**Date:** January 3, 2022

**File:** 1913 - 1335 & 1339 Bank Street

**RE: RESPONSE TO COMMENTS - POST ZBA | 1335 & 1339 BANK STREET | D07-12-21-0031**

6 TREE PLANTING Scale: 1:30

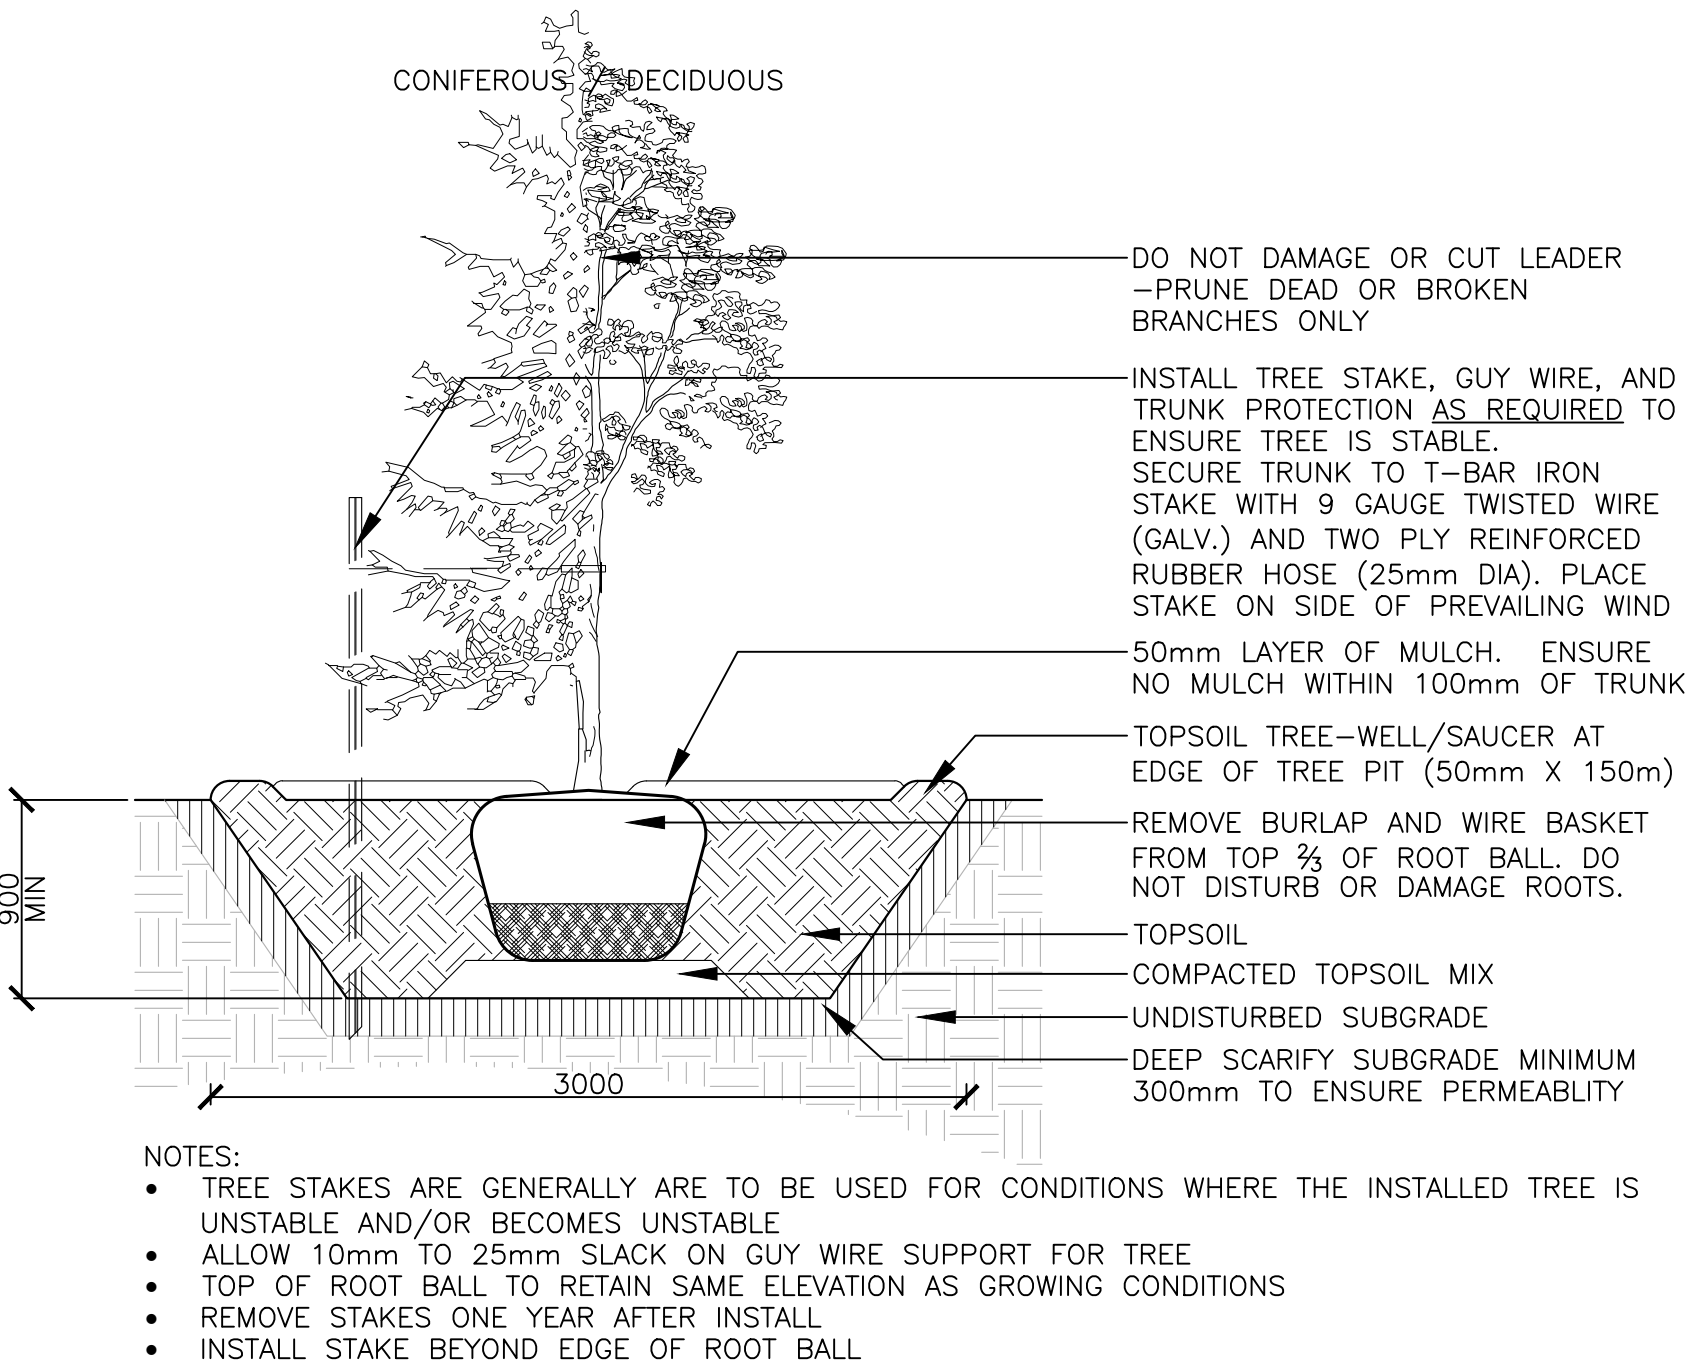
52. Further attempts should be made to provide additional trees on the site. The tree they are proposing indicates that the curb will be a flush concrete curb with a bollard at each corner. Instead of the bollard, the City would prefer to see a raised concrete curb as is shown in the photo below. This will allow for better tree growth. The City would also like to see a detail of the underground planting detail and the species they are proposing.

**Response from CSW:** *Trees have been proposed where feasible on site. Additional street tree planting is anticipated on this block as part of the Bank Street Reconstruction project, and will be coordinated.*
